KEMPS CREEK ESTATE – SSD-9522 MOD 3

Response to Request for Information

Frasers Property Industrial (**Frasers**) and Altis Property Partners (**Altis**) (referred to as the '**Frasers and Altis Kemps Creek JV**') received comments from a number of State and local authorities in response to the SSD-9522 MOD 3 Modification Report issued to DPE on 26 November 2021. The State and local authorities include:

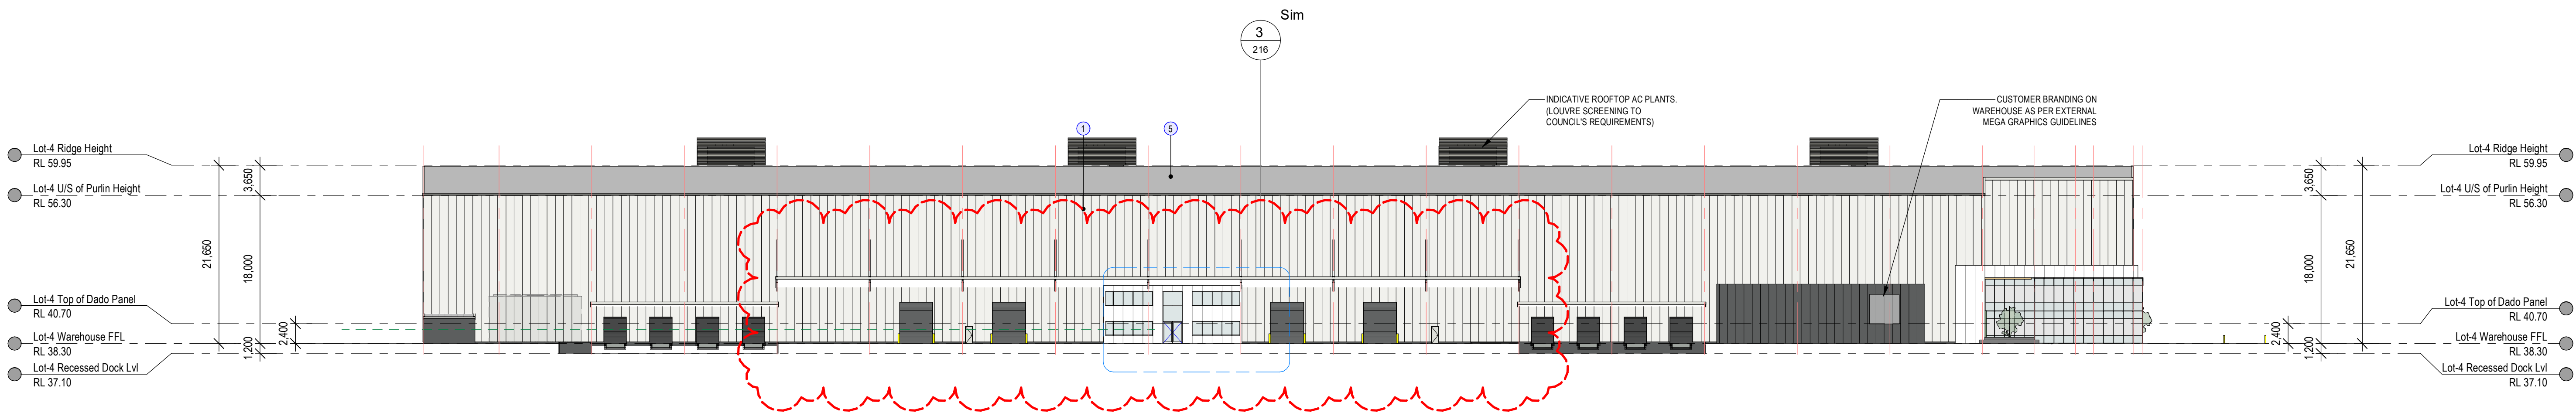
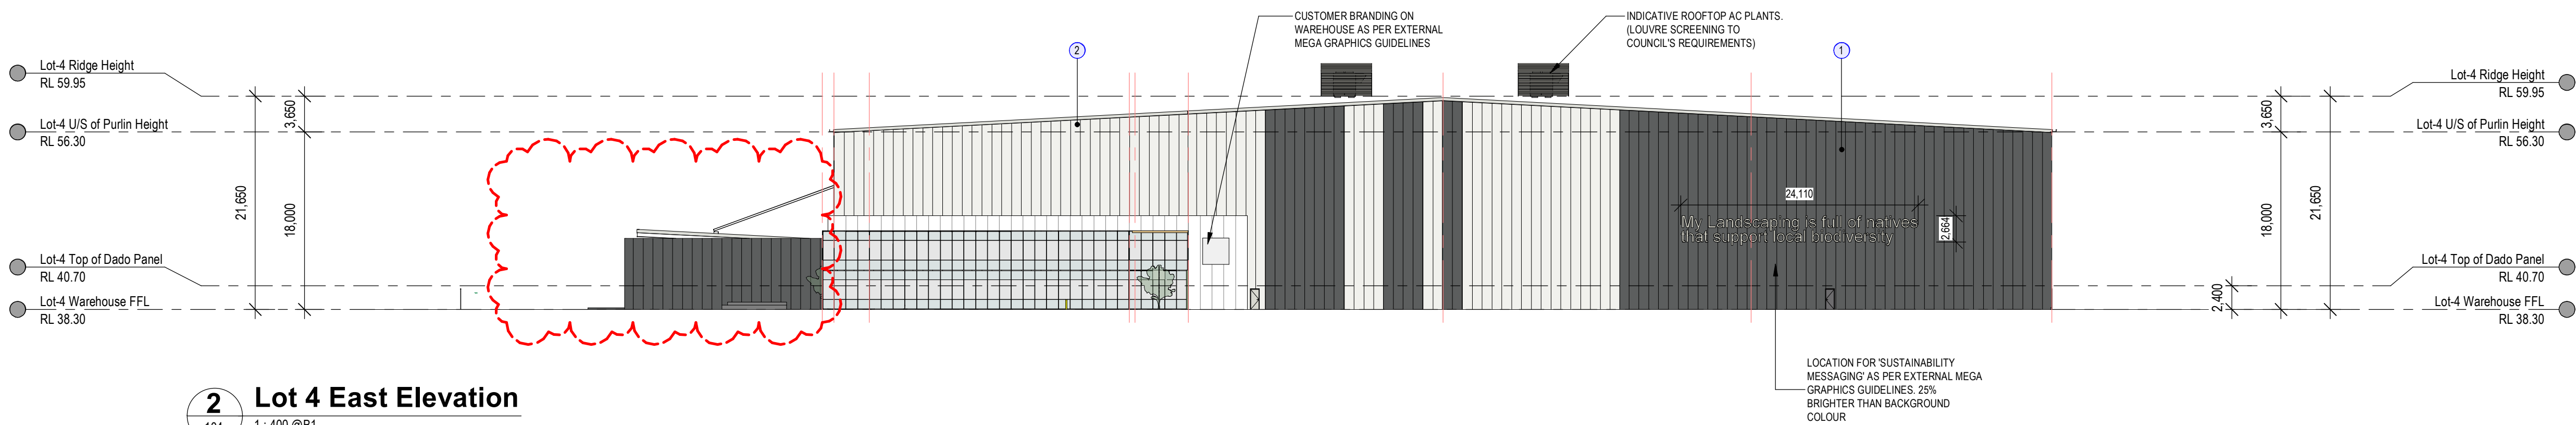
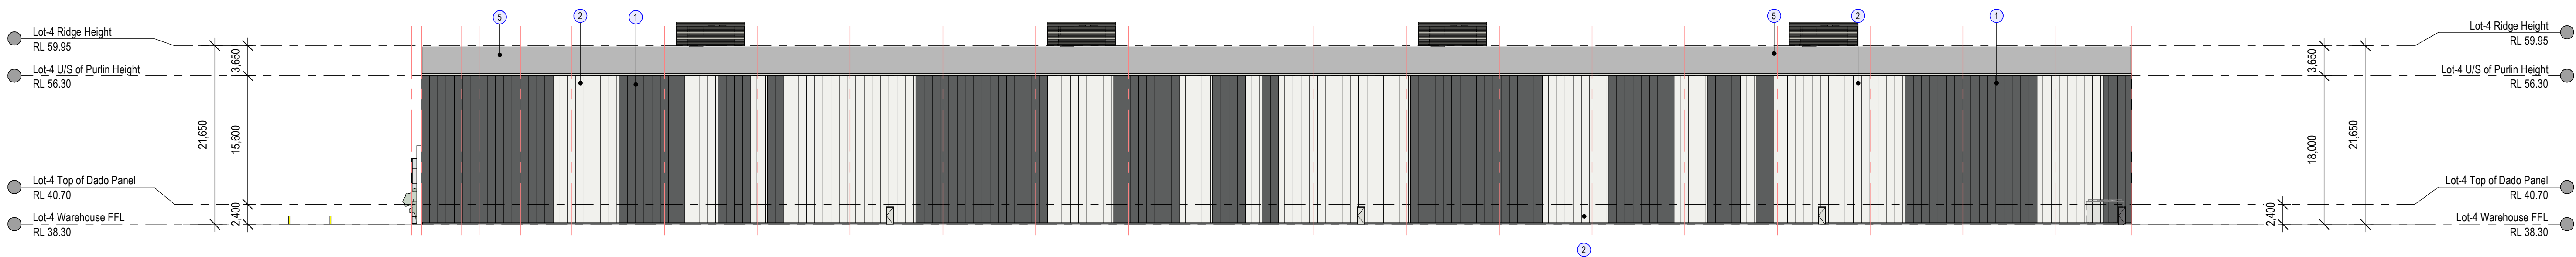
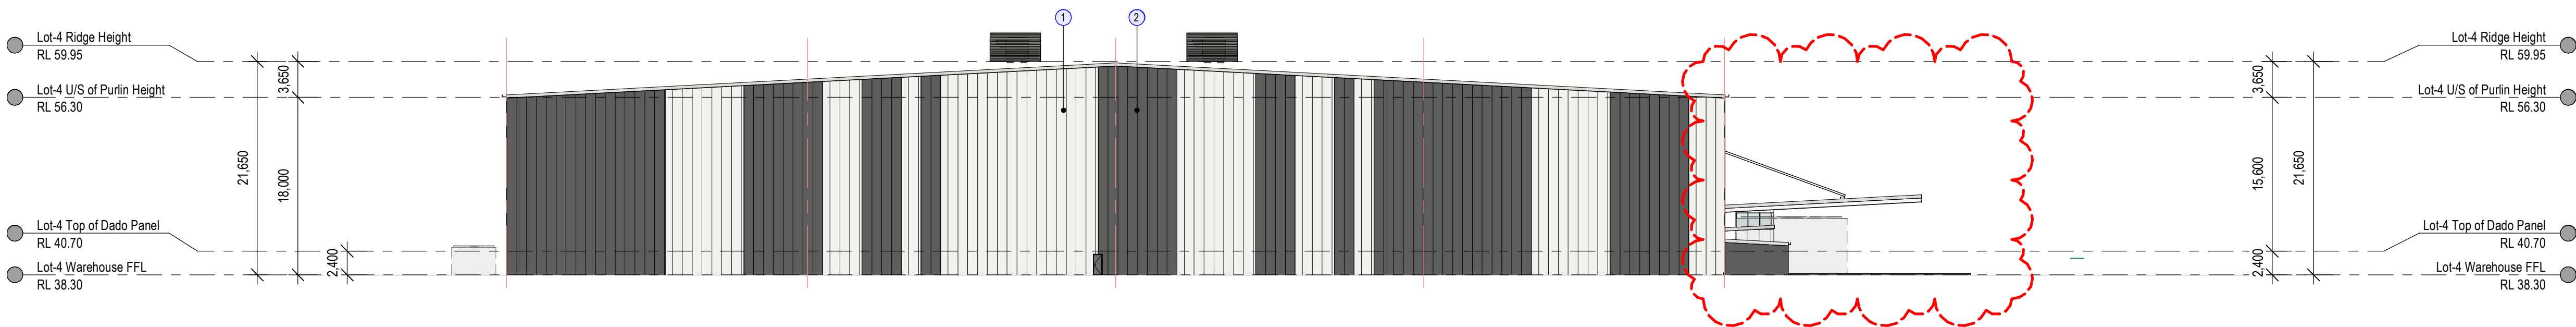
<p>The proposed awning and columns within the setback area do not comply with the development controls in Condition A7.</p>	<p>The proposed nine support structures in Lot 4, as shown below, are no longer proposed as part of SSD-9522 MOD 3. The proposed awnings and columns were part of a previous requirement for a potential tenant who are no longer in agreement for Lot 4 and Warehouse 4.</p> <p>Hence, this previous non-compliance which was proposed on strategic merit is no longer required.</p>	<p>Appendix A in this Response Table</p>
<p>The Visual Impact Assessment (Appendix B) should include consideration of the rooftop plant proposed for Lots 2 and 4.</p>	<p>The Visual Impact Assessment has been updated by Geoscapes to include the rooftop plant proposed within Lots 2 and 4.</p> <p>The VIA concludes that the roof equipment to Warehouses 2 and 3 is most visible from Mamre Road as demonstrated within VP 21. However, when comparing the impact of the roof equipment compared to the overall bulk and scale of the previous MOD1 scheme, it is not considered to be a significant visual detractor.</p>	<p>Appendix B of this Response Table</p>
